**RE: Request for Information for File No. SUB16-011  
7239 LLC 2-lot Short Plat  
7239 SE 27th St / Mercer Island WA 98040; King County Tax Parcel #: 5315100695**

Robin,  
Thank you for your request for information dated March 14, 2017. Below I have reproduced your comments and questions and have included my responses in red. If you have any questions, please don't hesitate to call me at 425.486.1252 x2 or email me at [mark@meadgilman.com](mailto:mark@meadgilman.com).

# 7239 SE 27TH STREET SHORT PLAT

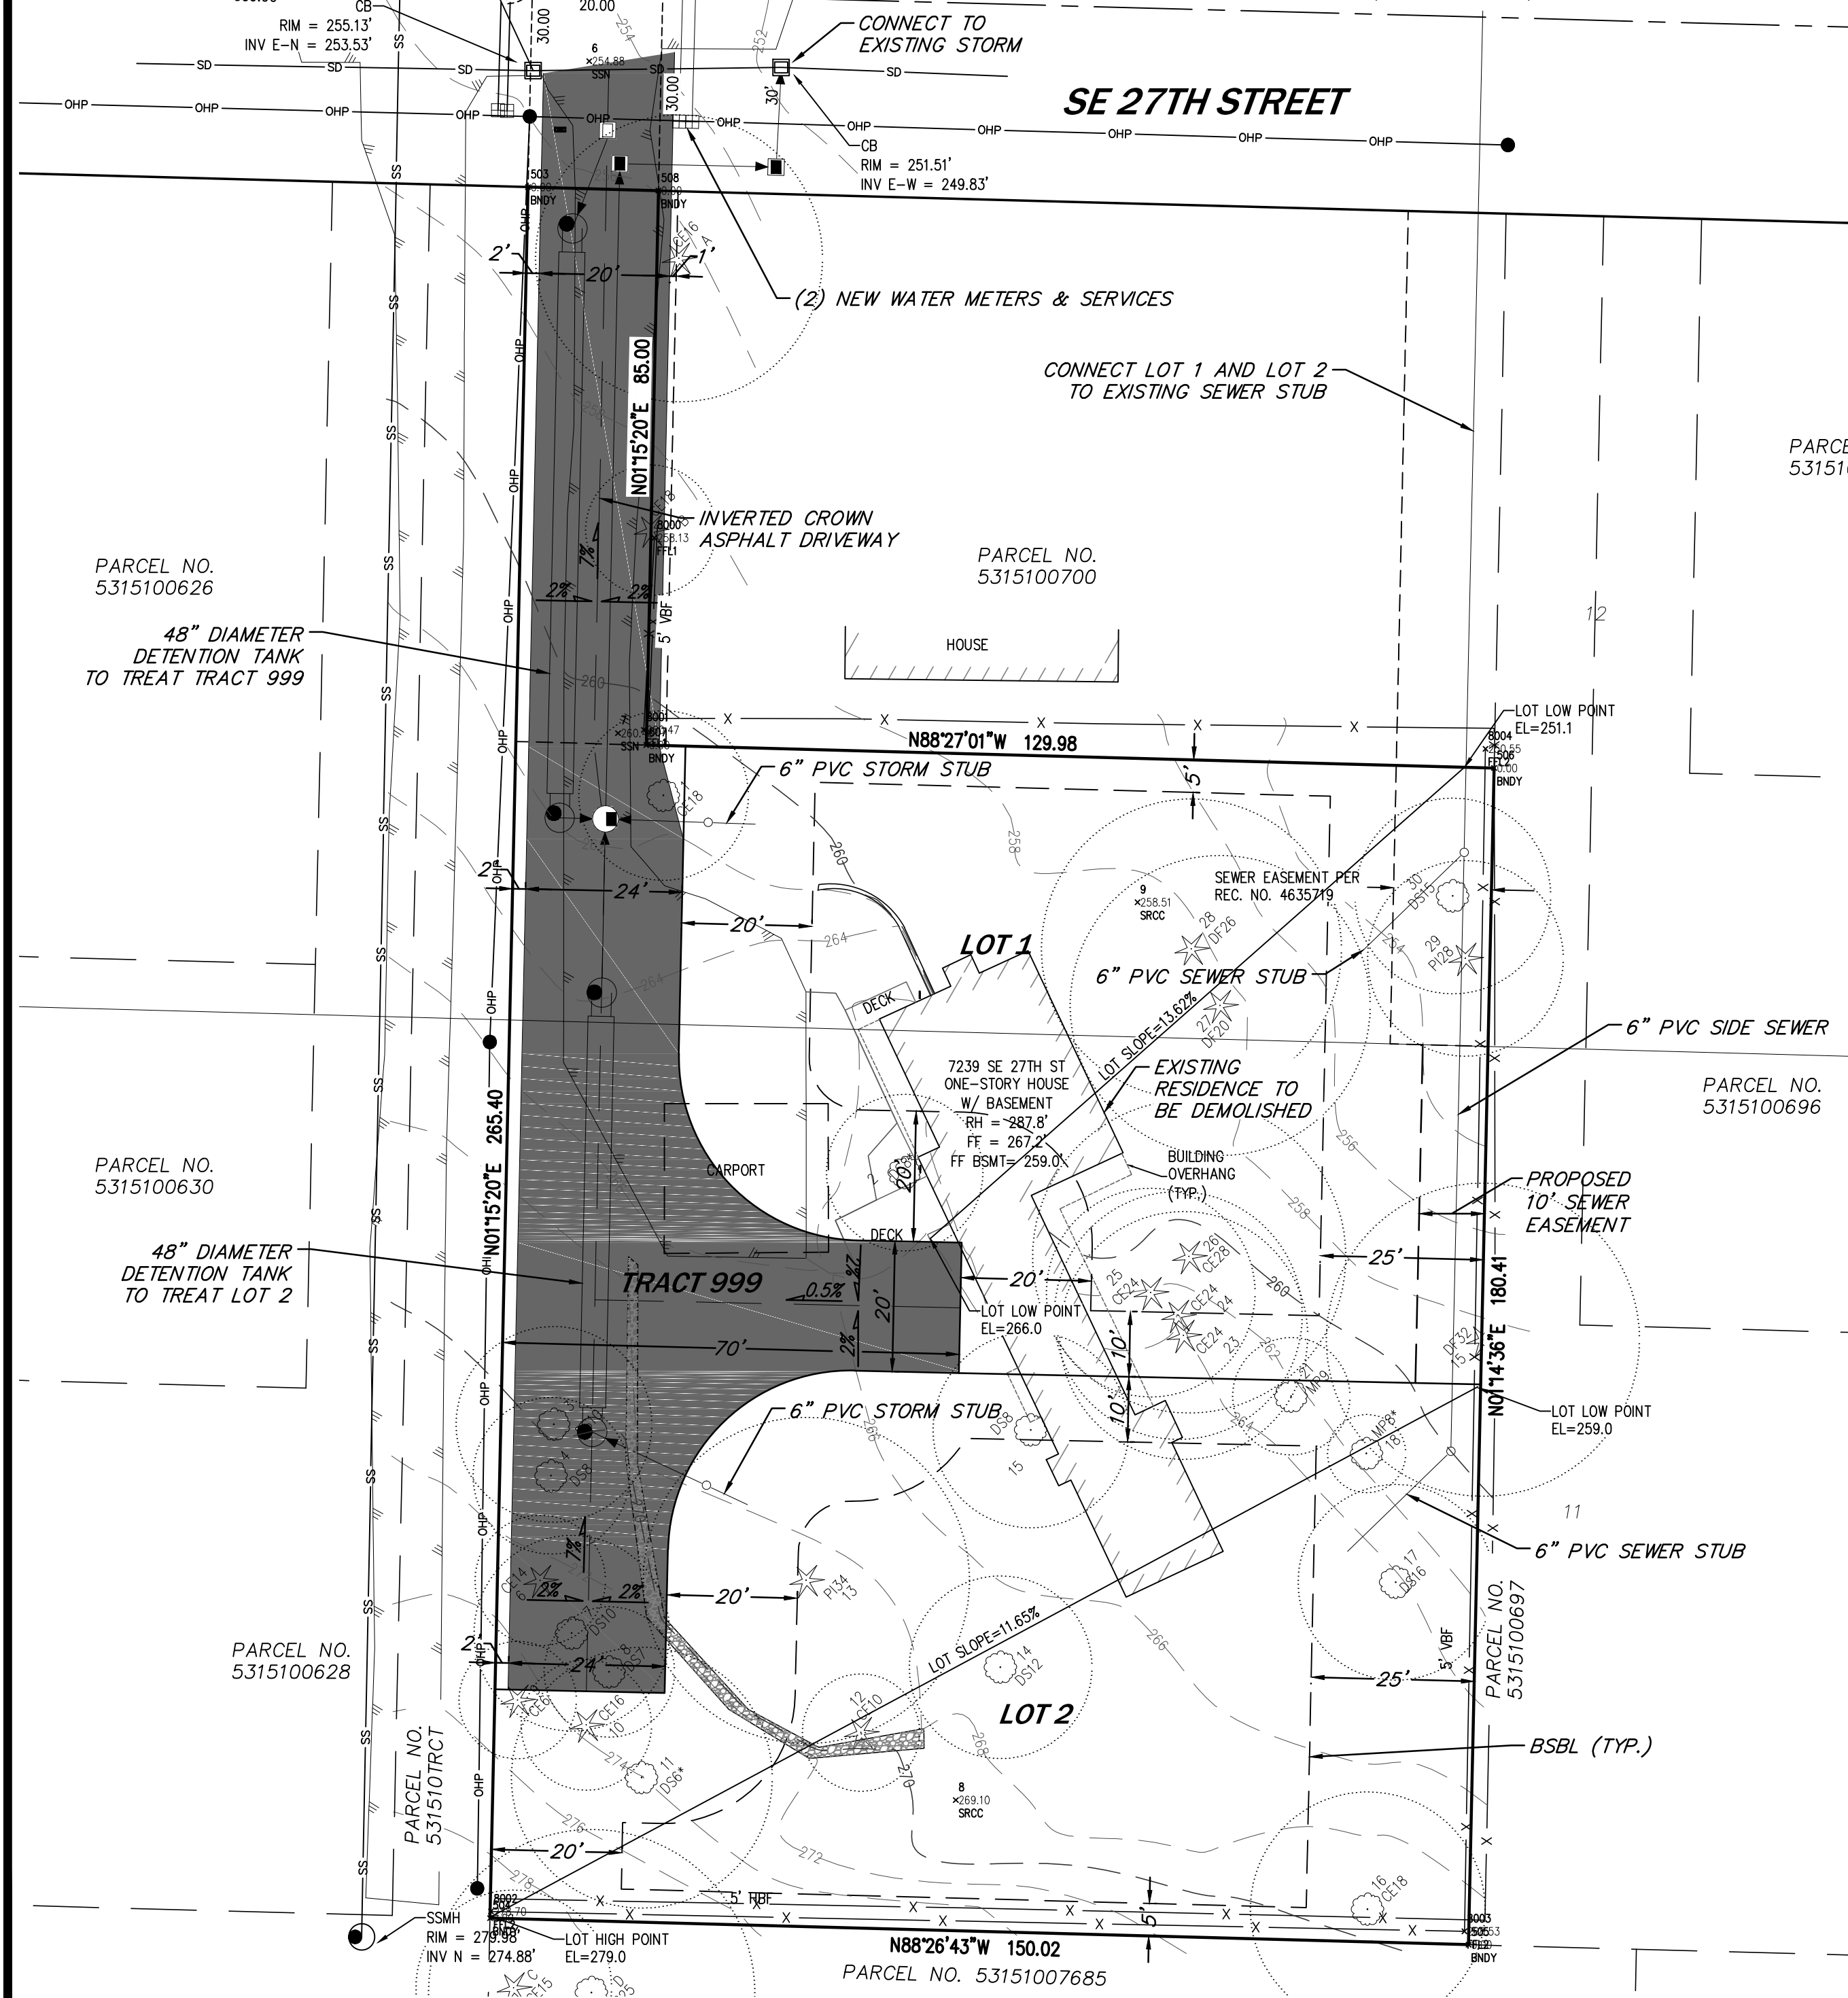
**Please see the attached letter written by the Geotech Ricky Wang**
4. Sheet 3 of the plan set shows "potential slide hazard line" and "erosion hazard line", which appear to match the mapped data available on the City's GIS system. Please show critical areas as field-verified, and ensure that the plan set shows geologic hazard areas as described in the geotechnical report.

**Please see the critical areas report prepared by the biologist, Gary Schulz**
6. Setbacks shown, but no building pad. Please designate a building pad meeting the standards in 19.09.090.

**Building pads are now shown on the 3<sup>rd</sup> sheet of the proposed short plat**
7. Please draw and call out the limits of site disturbance.  
**Limits of site disturbance are now shown on the 3<sup>rd</sup> sheet of the proposed short plat**

1. The proposed lot layout and utility layout does not do enough to retain healthy trees on both lots. Show the following trees to be protected throughout site development and building: Trees, 13, 29, 32, C, D. Have the Project Arborist establish limits of disturbance for all of these trees. Once these limits of disturbance are established, a lot and layout can be created. This should include full root zone analysis with air tool by certified Arborist. Limits of proposed disturbance

should be marked in the field for the TRAQ Qualified Arborist visit. Limits of excavation of all encroachment into these driplines need to be shown on the plans and marked in the field.

**Please see the attached letter written by the Geotech Ricky Wang. The map has been updated to remove the city's GIS mapping and reflect the attached Geotechnical report.**

Please see the arborist report and updated layout on sheet 3.
